Recommendation Report for Planning Permission for Works or Extension to a Dwelling

REF NO: WA/65/18/HH

LOCATION: Richmond House
Arundel Road
Walberton
BN18 0QP

PROPOSAL: Retention of double garage & with new layout to screening to the North West highway boundary.

ELEVATION PLAN

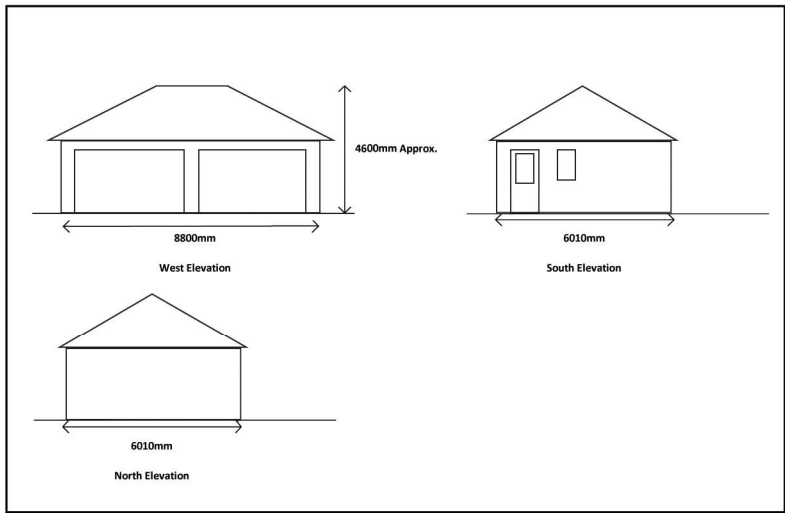
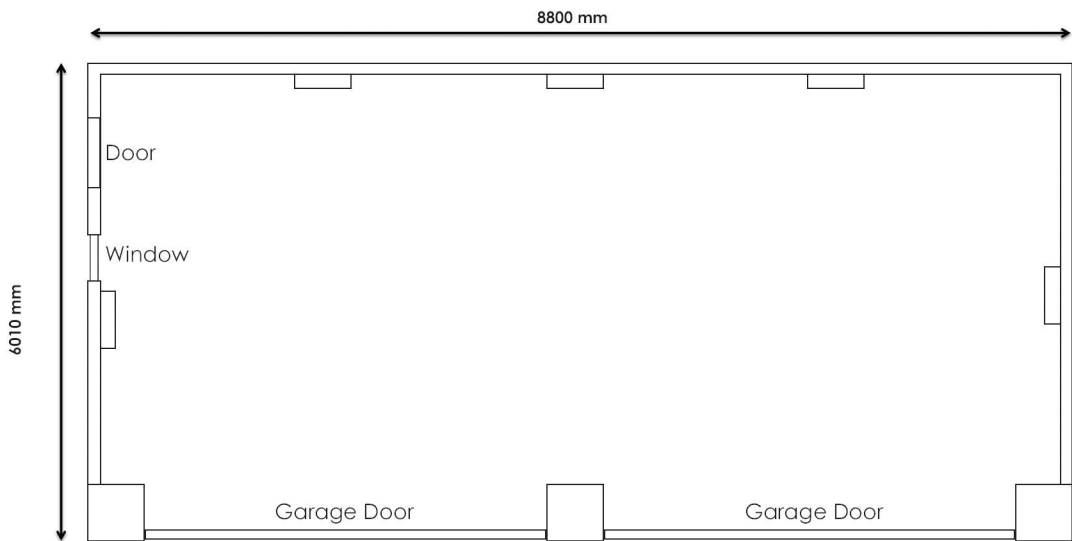
Due to its prominent location within the street scene the proposed front garage will alter the existing appearance and layout of the residential unit in which it is sited. The proposed development is considered to appear subservient within the residential plot, resultant of its modest design, and matching materials. The materials match the existing dwelling, which allows the garage to far easier 'blend in' and appear less prominent and obtrusive of a feature within the street scene.

The separation distance between the garage and the footpath is less than 7m, however, as a result of the proposed additional boundary screening, the garage is not considered to have a significantly harmful impact upon the street scene, or the established character of the area.

The proposed development is not considered to have any significantly overbearing or overshadowing impact as a result of intervening foliage and significant separation distance between the proposal site and neighbouring dwellings. The garage is single storey, and resultantly the available views would be no different from those that are currently available from the front garden.

NEW PLANTING AT NORTH SIDE OF PROPERTY FRONTING ARUNDEL ROAD 1/125

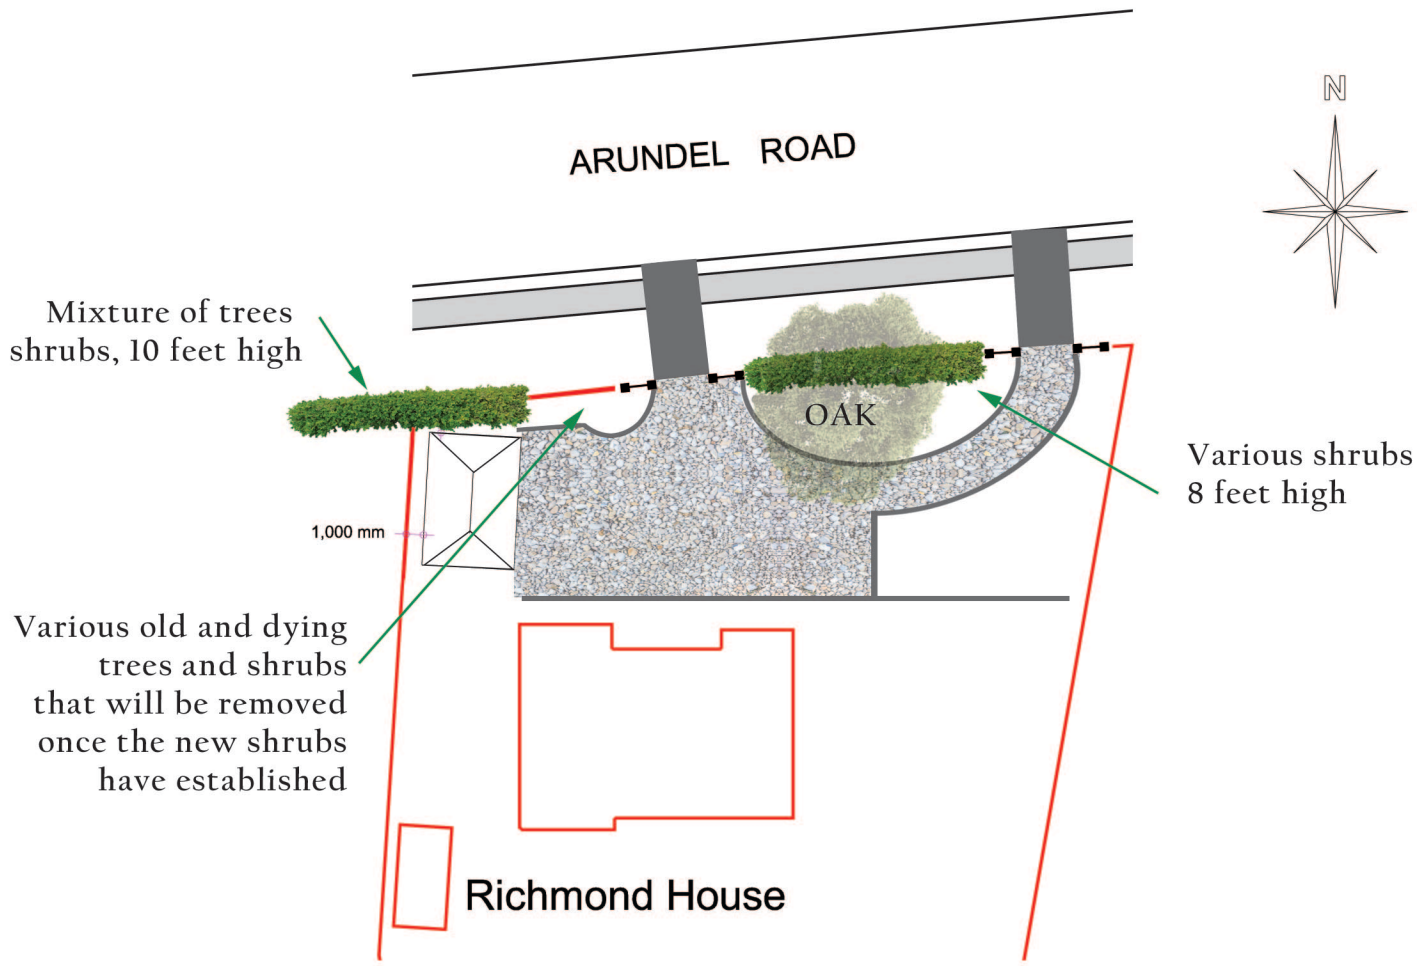
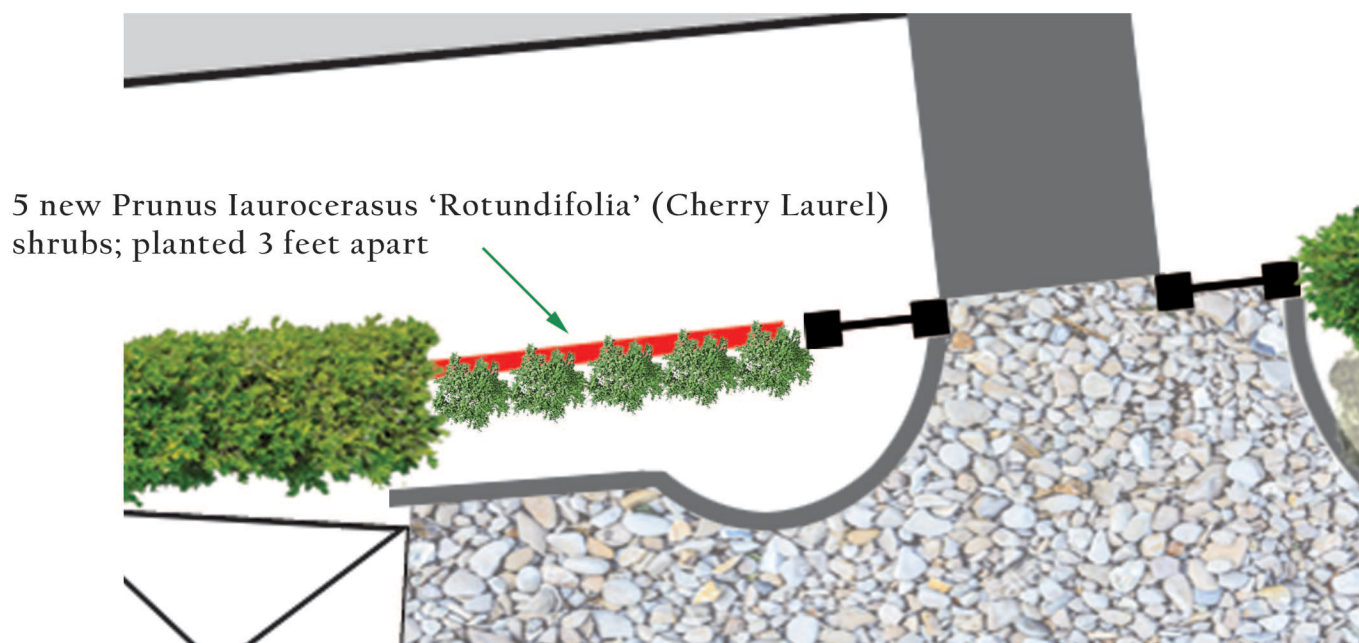
The application is for the alteration to planting. A comment has been provided stating concerns about the effect of proposals on surface and sub surface flows. The proposals are to replace existing dying plants with a new laurel hedge. This shouldn't have a negative impact upon flows. The new growth should provide more interception.

- No development or new tree planting should be located within 3 metres either side of the external edge of the foul sewer.
- No new soakways should be located within 5m of a public sewer.
- All existing infrastructure should be protected during the course of construction works.
